Cottam Solar Project

Statement of Common Ground with Upper Witham Internal Drainage Board [Revision A](#)

PINS Ref: EN010133

Document reference: ~~EX1EX4~~/C8.3.7 [_A](#)

Figure 8.16.7.1: Landscape and Ecology Mitigation and Enhancement Plan – Cottam 1 West Option A (Sheet 2) Revision A

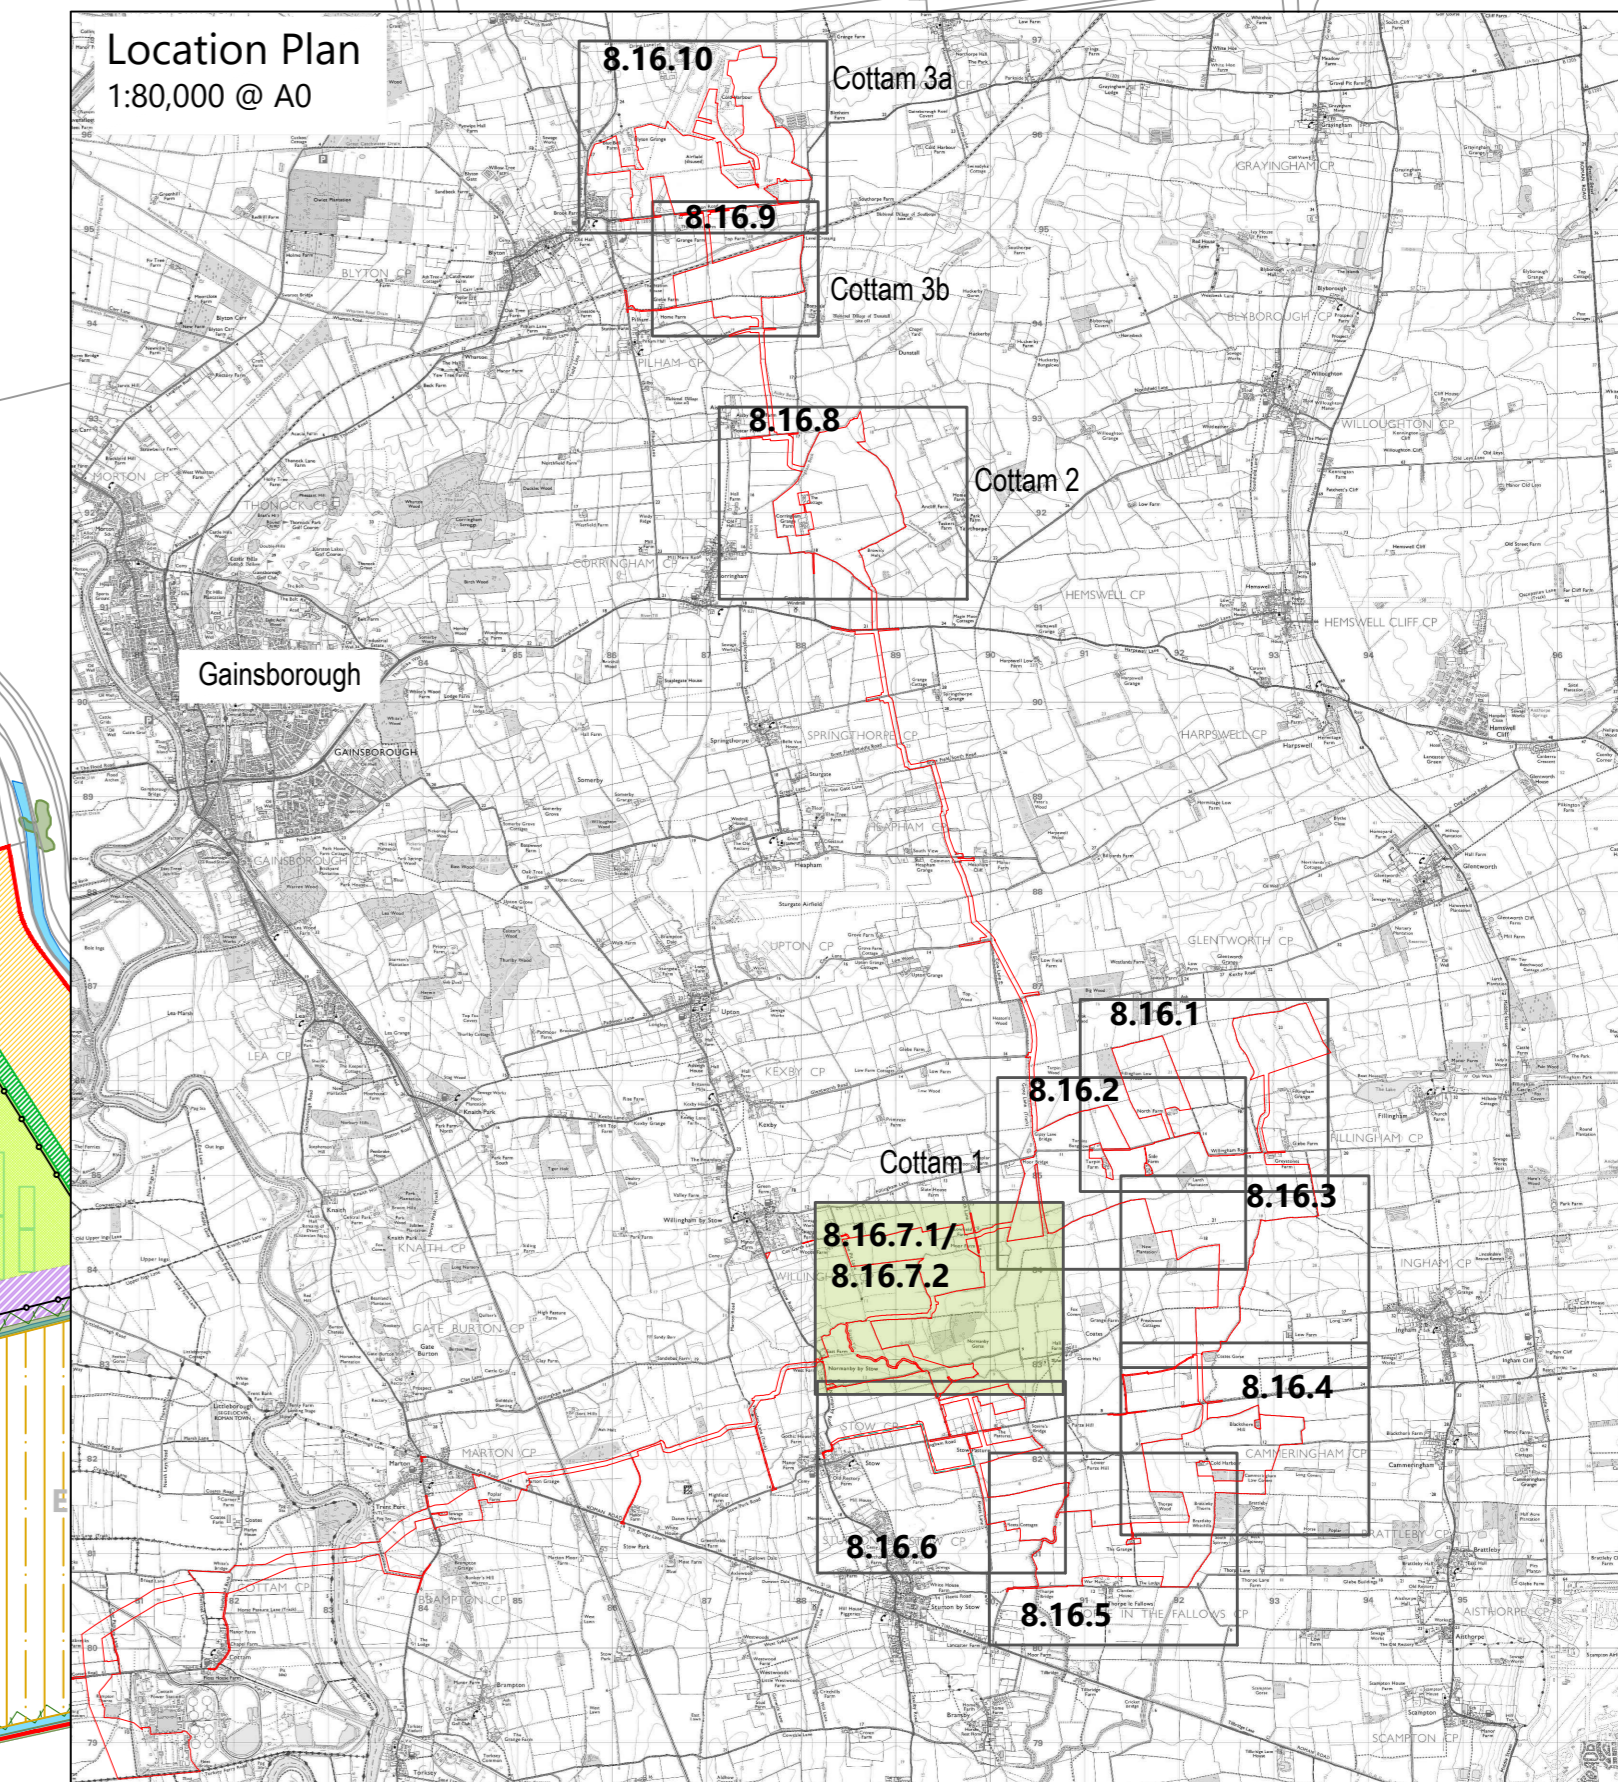
<ul style="list-style-type: none"> • IDB watercourses not clearly identified. <p>0700 - Cricket Till o Fencing and potentially solar panels within the 9m Byelaw distance (from the top of the bank) preventing access for maintenance Figure 8.16.7.1 & 2</p> <p>IDB watercourses not clearly identified. • 0500 - East Till o Fencing, planting and potentially solar panels within the 9m Byelaw distance (from the top of the bank) preventing access for maintenance</p> <p>0400 - Padmoor Drain o No comments</p> <p>0106 - Throops Drain o Fencing, planting and potentially solar panels within the 9m Byelaw distance (from the top of the bank) preventing access for maintenance Figure 8.16.6</p> <ul style="list-style-type: none"> • IDB watercourses not clearly identified. <p>0106 - Throops Drain o Fencing, planting and potentially solar panels within the 9m Byelaw distance (from the top of the bank) preventing access for maintenance Only Cottam 1 is within the area relevant to Upper Witham IDB. For Cottam 2 and Cottam 3A/3B Scunthorpe & Gainsborough IDB should be consulted.</p>

Figure 8.16.6: Landscape and Ecology Mitigation and Enhancement Plan – Cottam 1 West (Sheet 1) Revision A

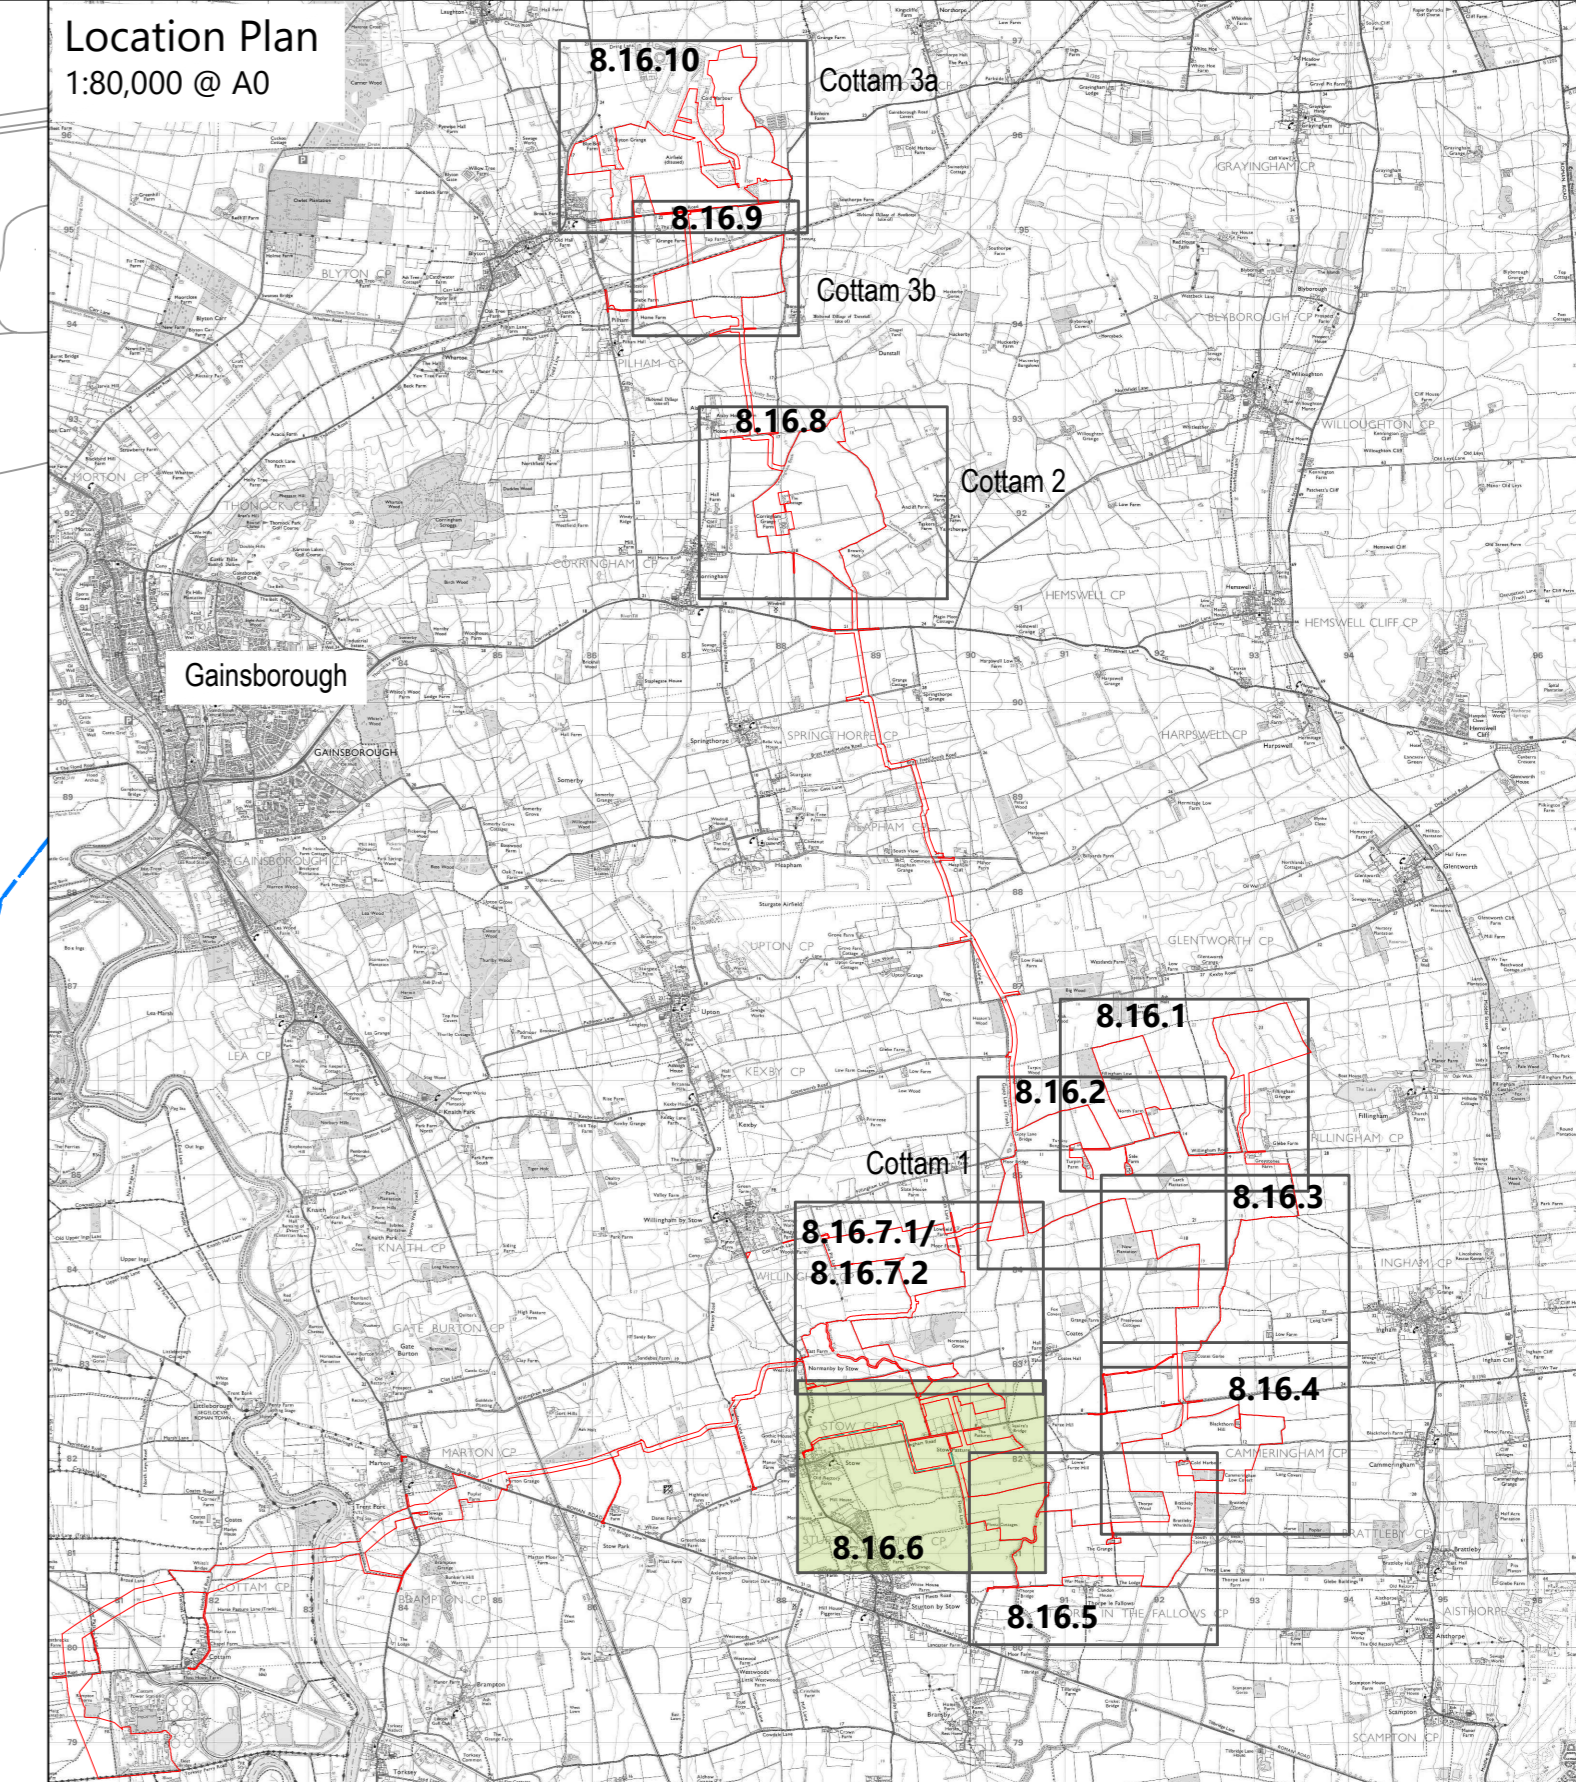
<p>0400 - Padmoor Drain. No comments.</p> <p>0106 - Throops Drain. Fencing, planting and potentially solar panels within the 9m Byelaw distance (from the top of the bank) preventing access for maintenance.</p> <p>Figure 8.16.6: IDB watercourses not clearly identified.</p> <p>0106 - Throops Drain. Fencing, planting and potentially solar panels within the 9m Byelaw distance (from the top of the bank) preventing access for maintenance.</p>	
<p><u>Hydrology</u> <u>HY-04</u></p>	<p>Provision of Works</p>	<p><i>Provision of any culverts, outfalls and other works within all watercourses (apart from Environment Agency main river.)</i></p> <p><i>Within the Upper Witham IDB district under the terms of the Land Drainage Act. 1991 the prior written consent of the Board is required for any proposed temporary or permanent works or structures within any watercourse including infilling or a diversion.</i></p> <p><i>Within the extended area of Upper Witham IDB under the provisions of the Flood and Water Management Act 2010, and the Land Drainage Act. 1991, the prior written consent of the Lead Local Flood Authority (Lincolnshire County Council) is required for any proposed works or structures in any watercourse outside those designated main rivers and Internal Drainage Districts. At this location this Board acts as Agents for the Lead Local Flood Authority and as such any works, permanent or temporary, in any ditch, dyke or other such watercourse will require consent from the Board.</i></p>	<p>The IDB have asked for this item to be included within the Statement of Common Ground. The Applicant notes the requirements and will ensure that the project adheres to these as and when required. Protective provisions for the benefit of the IDB are included in part 8 to Schedule 16 of the draft DCO [AS-012] which require that the IDB be consulted and approve any “specified works” within 9m of any of the IDB’s drains/watercourses.</p>
